City of Portland, Maine – Building or Use Permit Application 389 Congress Street, 04101, Tel: (207) 874-8703, FAX: 874-8716

Location of Construction: 40 Epping Street		Owner: *** Richard Delgiasi	Phone: *** 878-2678	Permit No: 001229
Owner Address: 40 Epping Street, Portland, ME 04103		Lessee/Buyer's Name:	Phone:	Business Name:
Contractor Name:	Address:		Phone:	Permit issued: NOV - 1 2000
Past Use: Single Family	Proposed Use: Single Family	COST OF WORK: \$2,000.00	PERMIT FEE: \$36.00	
		FIRE DEPT. <input type="checkbox"/> Approved <input type="checkbox"/> Denied	INSPECTION: Use Group A-3 Type: 5B	Zone: CBL: 307-D-016
Proposed Project Description: Add roof and enclosed walls to 13 x 14 deck		Signature:	Signature: <i>[Signature]</i>	Zoning Approval: Special Zone or Reviews: <input type="checkbox"/> Shoreland <input type="checkbox"/> Wetland <input type="checkbox"/> Flood Zone <input type="checkbox"/> Subdivision <input type="checkbox"/> Site Plan maj <input type="checkbox"/> minor <input type="checkbox"/> mm <input type="checkbox"/>

BUILDING PERMIT REPORT

DATE: 27 OCT. 2008 ADDRESS: 40 Epping St. CBL: 307-D-016
 REASON FOR PERMIT: Enclose deck - roof -
 BUILDING OWNER: Richard Del

FOUNDATION & DECK

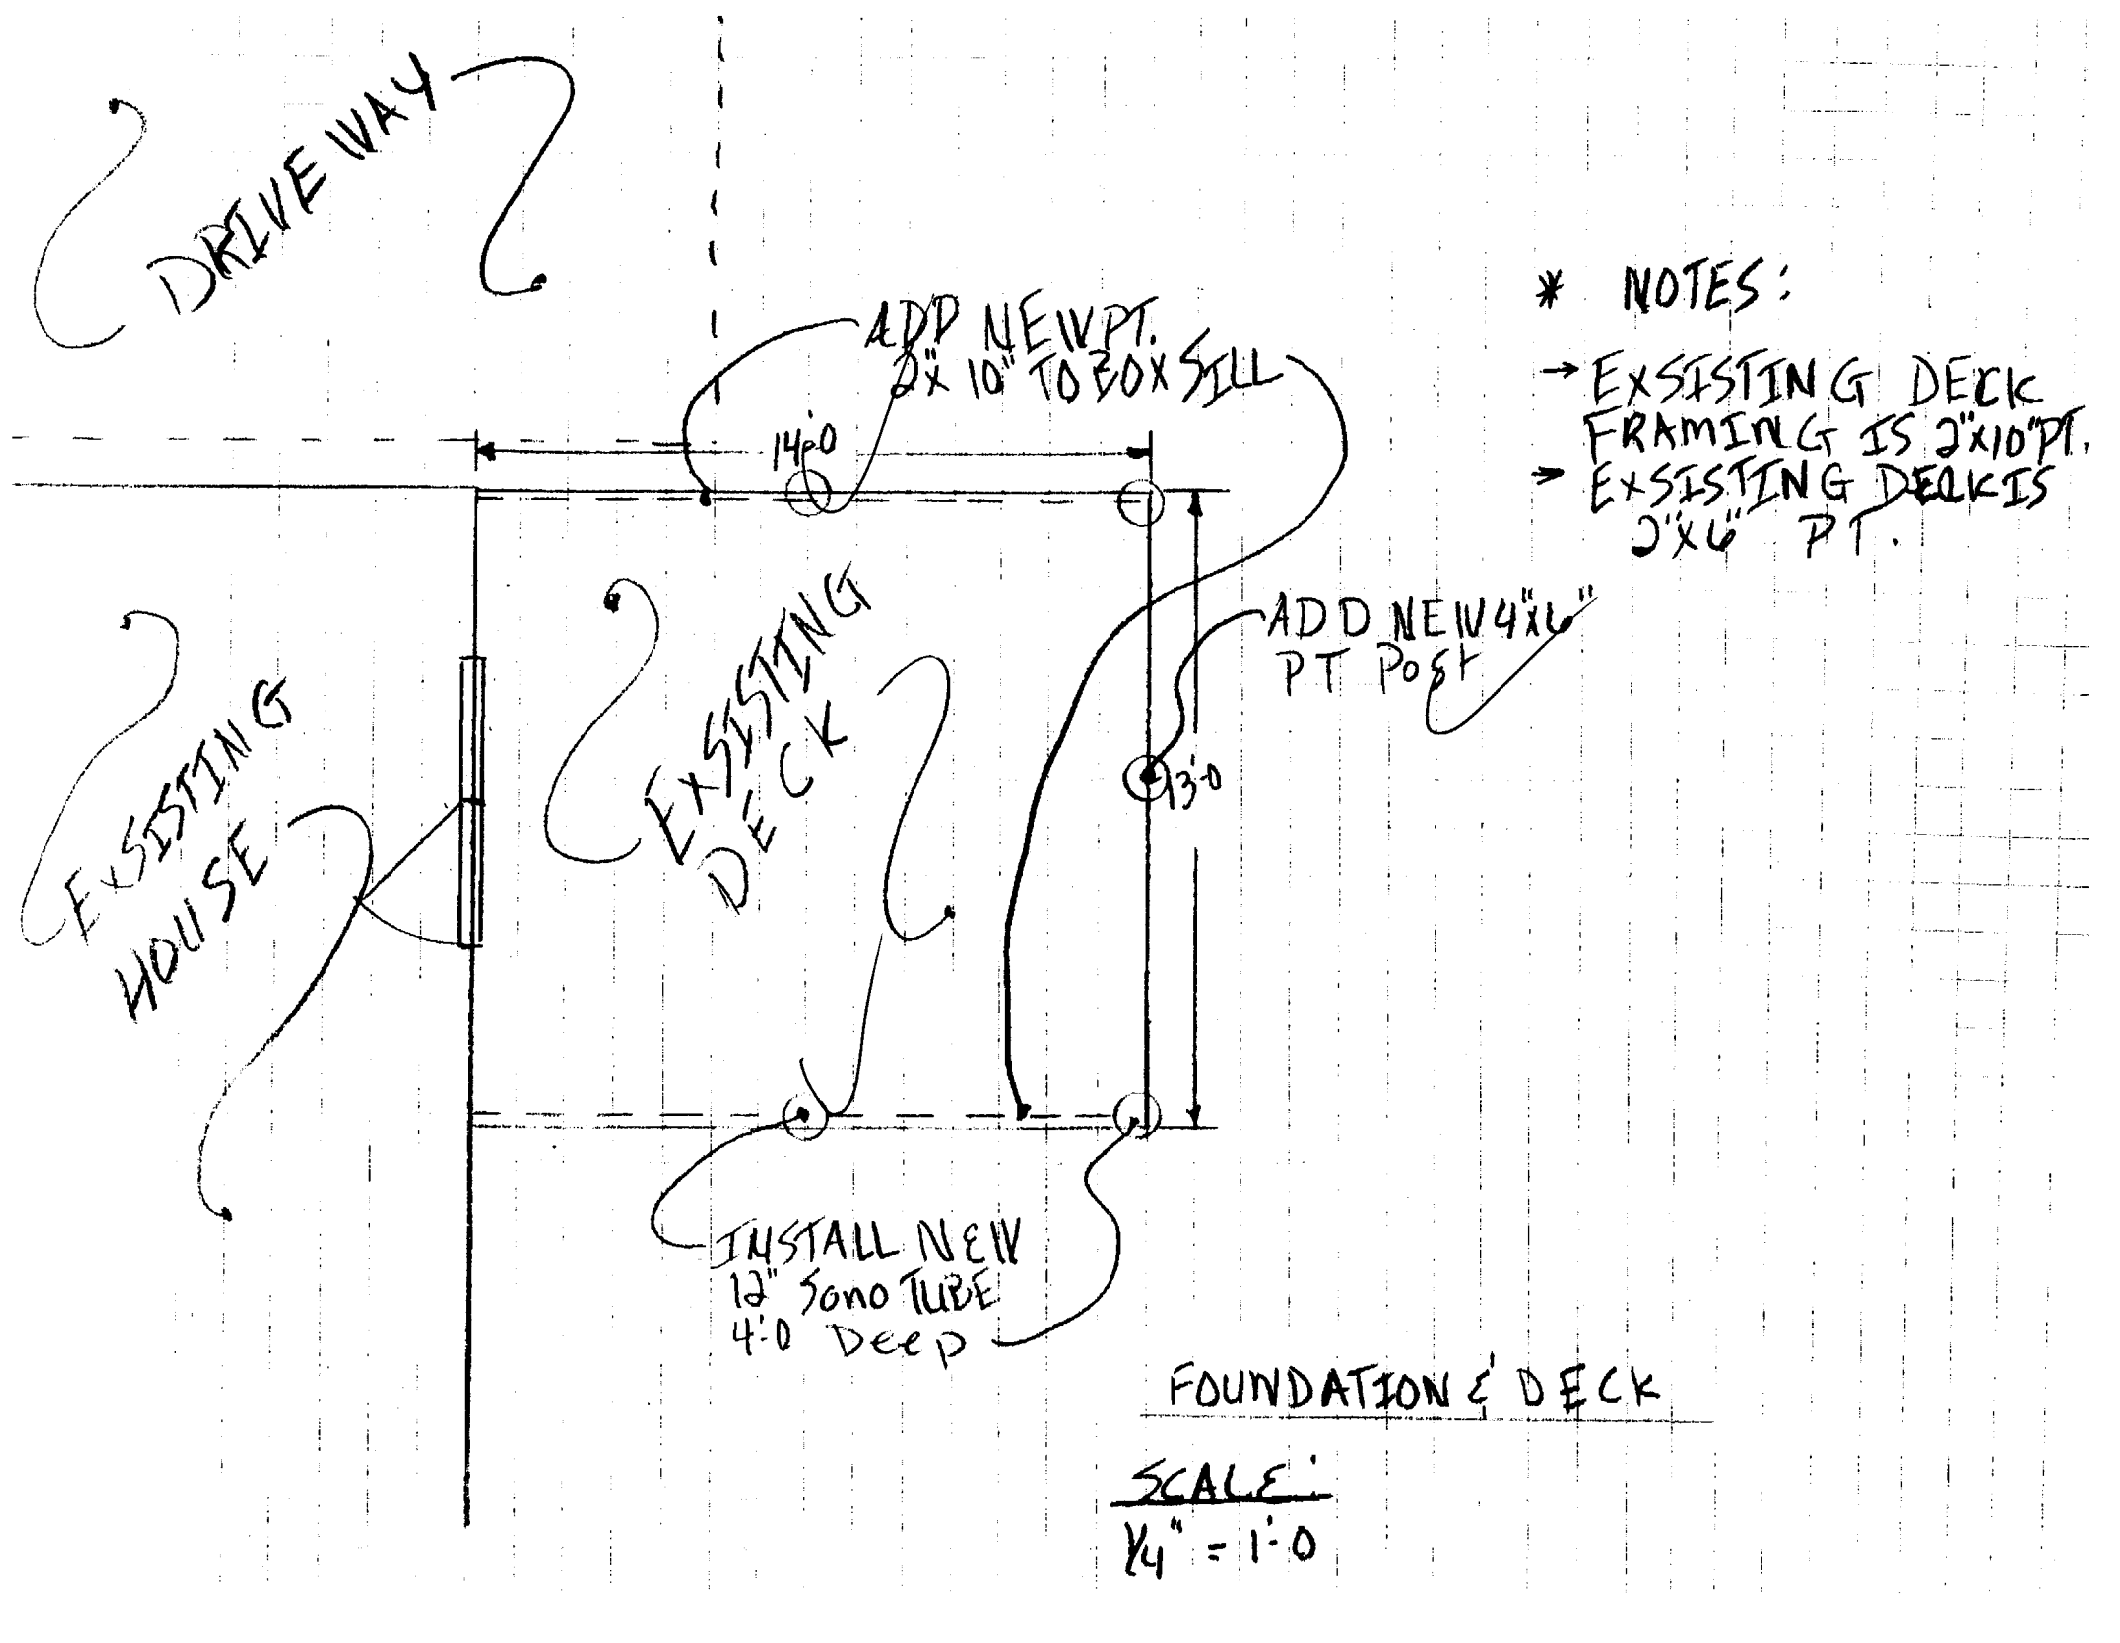
11-3 INMAGUATE
SOME TUBES - OWNER
NEEDS TO SUBMIT
REVISED PLANS FOR
PROJECT - SEE SAWS
NOTE.

11-2500: Met w/owner to review plans. Informed Him THAT ADDITION OF (4) SOUP TUBES & 4X6 Carrying timber are needed. SKW, Owner told me that project is off till spring.

- X36. All flashing shall comply with Section 1406.3.10.
- X37. Before work is started The Framing of The existing deck shall be checked to verify the Foundation system is capable of carrying the extra load of door, windows, wall and roof.
